Application for Approval of Details Reserved by Condition

Change of use from C4 house in multiple occupancy (HMO) to sui generis HMO for 7 bed and 7 persons with no external alterations

27994/APP/2021/3581

Condition 2

1528-P-001

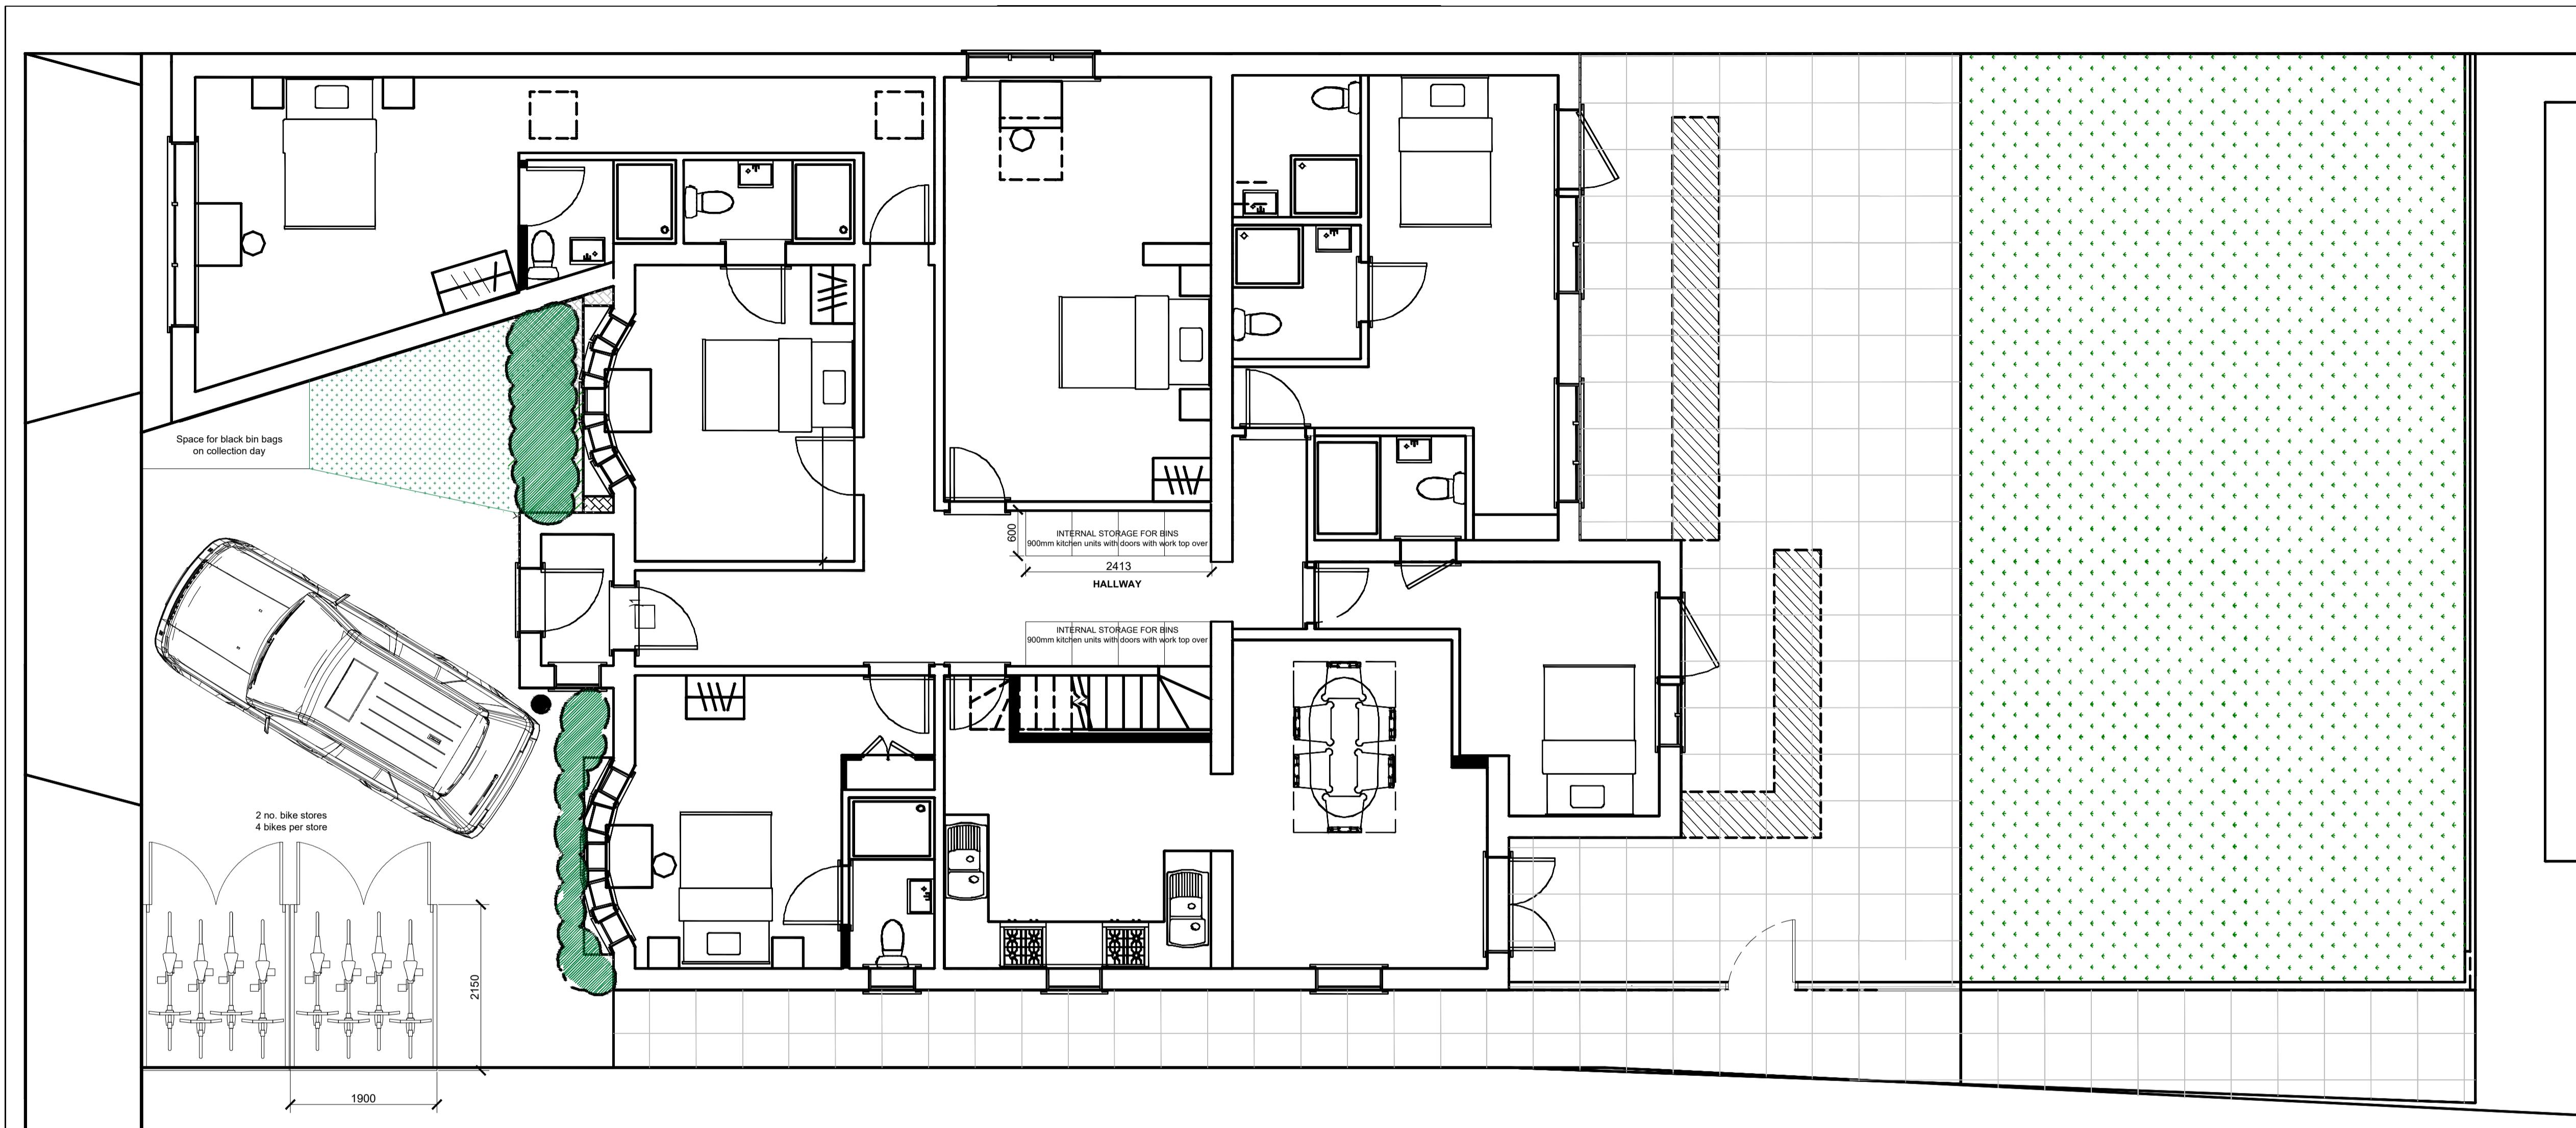
The applicant has submitted Drawing 1528-P-001 titled Block Plans which shows 2no. cycle stores accommodating 4no. cycles each, a total of 8no. cycles which would be an acceptable level of cycle parking, however, the location would not be acceptable. Cycle parking must concur with The London Plan (2021) Policy T5 cycling which requires cycle parking to concur with LCDS 8.5.3 Residential Cycle Parking which requires cycle parking spaces to be well located: close to the entrance of the property and avoiding obstacles such as stairs, multiple doors, narrow doorways (less than 1.2 metres wide) and tight corners.
